Application no: H16-0288-11

Description: Alterations and extensions to existing two-storey dwelling to form two separate apartments

Location: 45 Bourne Road
Spalding
Lincs
PE11 1JN

Amendment: Internal layout modified (dwg. no. 10/261/PA/002)

GROUND FLOOR APARTMENT

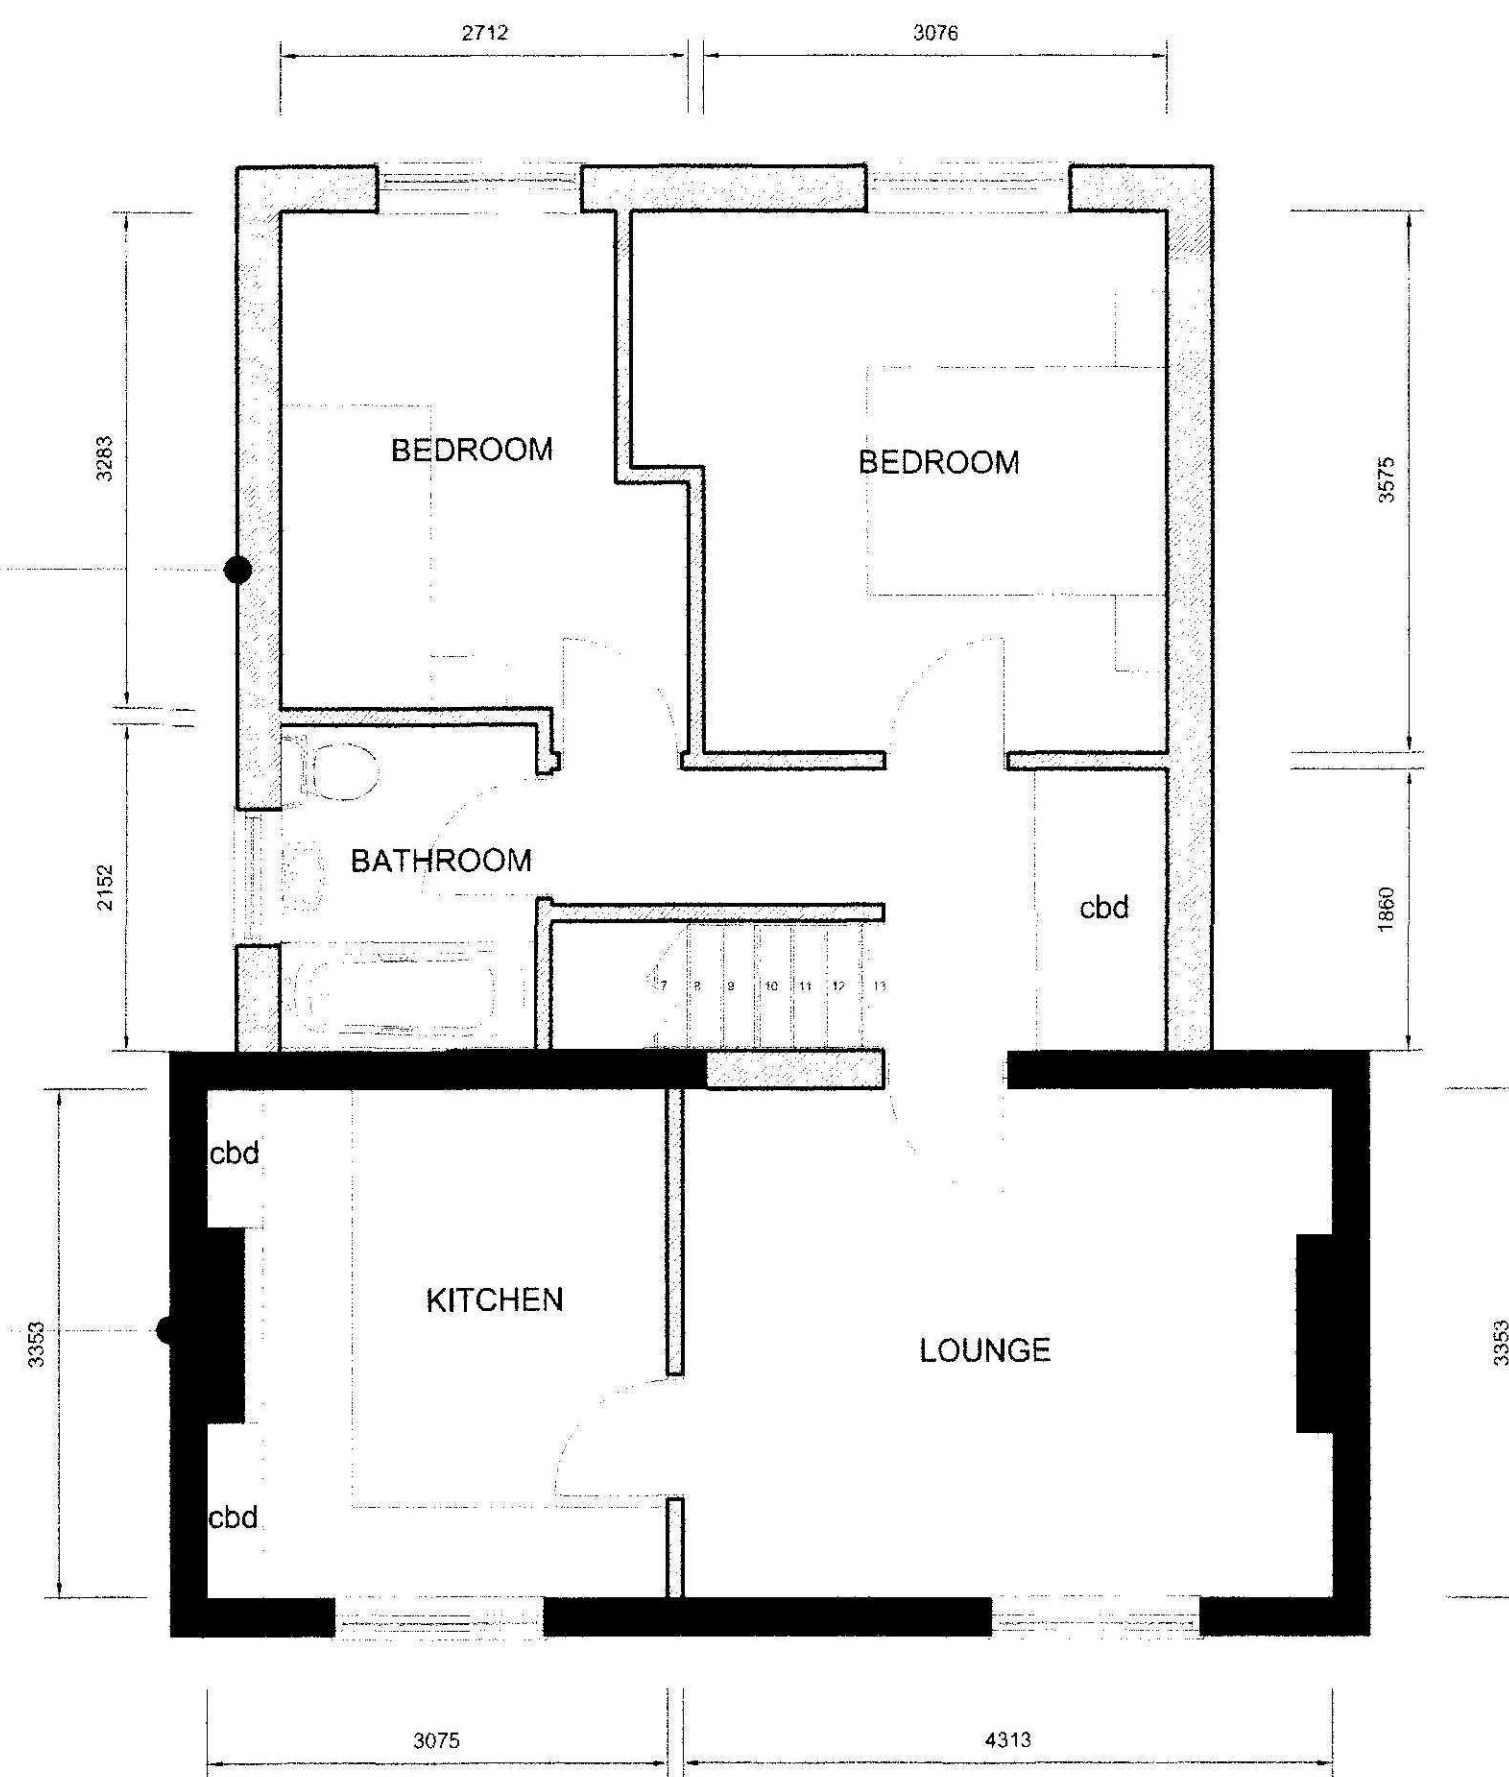
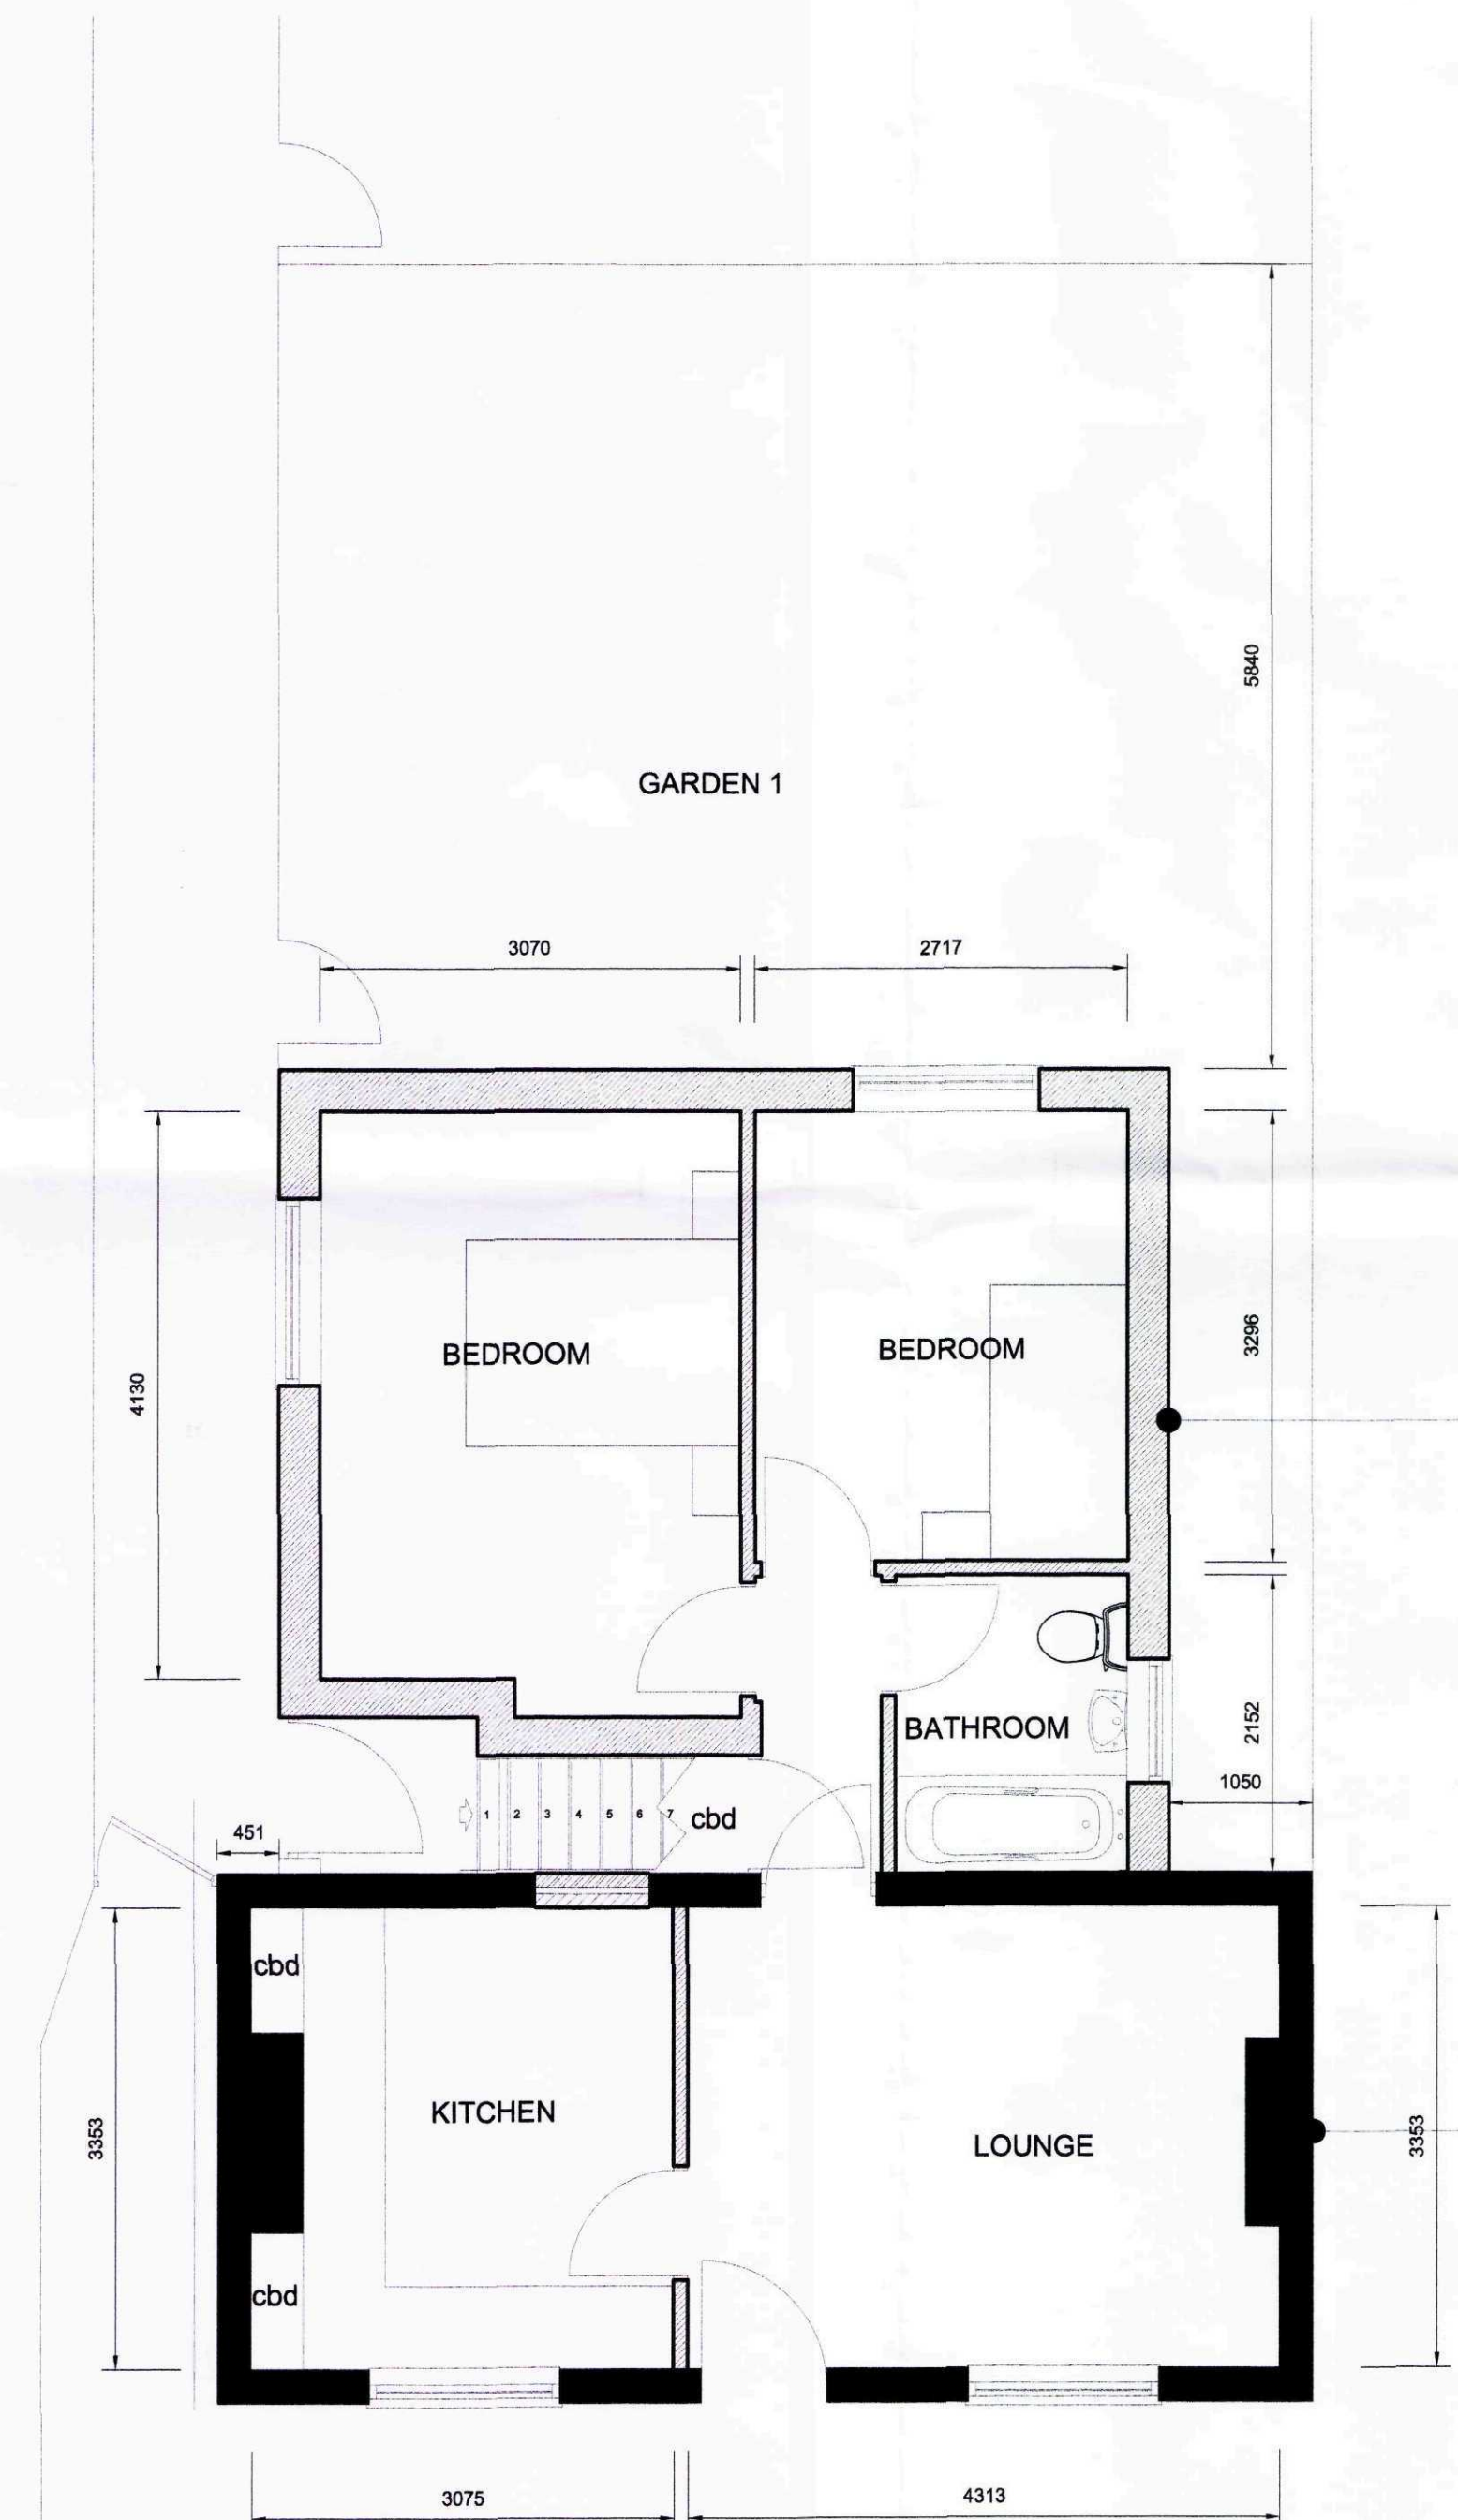
Although the kitchen and lounge areas meet the criteria for cooking eating and living given in our Residential Flat Conversions Policy dated February, 2010, the minimum internal dwelling area range is not quite met (57-67 square metres) and the two bedrooms on the first floor don't, I believe, meet the bedroom areas of 12 and 7 square metres.

- In apartment 1 I have chosen to show the storage area as the cupboards in the Kitchen. I am not sure whether this might be ducking the issue a little, although I would hope not. I am over-sized in both bedrooms however, by more than 1.5 sq m, which should allow for alternative storage provision sufficient to meet the requirements.
- Also in apartment 1, the overall area was 1.5 sq m below the minimum requirement, and so I have now shown an under-stair cupboard with an area of 1.5 sq m, which will deal both with storage allocation and overall floor area at a stroke.
- In apartment 2, I was marginally deficient in the double bedroom, but over-sized in the single bedroom. I have now nudged the dividing wall to bring the double bedroom up to 12 sq m, with a reduction in the single bedroom reducing its area to 8.12 sq m.

APARTMENT 1 – GROUND FLOOR	ACTUAL AREA – m ²	REQUIRED AREA – m ²
Lounge / Kitchen (CEL)	24.24	24
Double Bedroom	13.14	12
Single Bedroom	8.92	7
Dedicated Storage	4 in kitchen	1.5
Overall internal dwelling area	53.5	57 to 67
APARTMENT 2 – FIRST FLOOR		
Lounge / Kitchen (CEL)	24.24	24
Double Bedroom	11.82	12
Single Bedroom	8.3	7
Dedicated Storage	4 in kitch + 1.6 in hall	1.5
Overall internal dwelling area	58.7	57 to 67
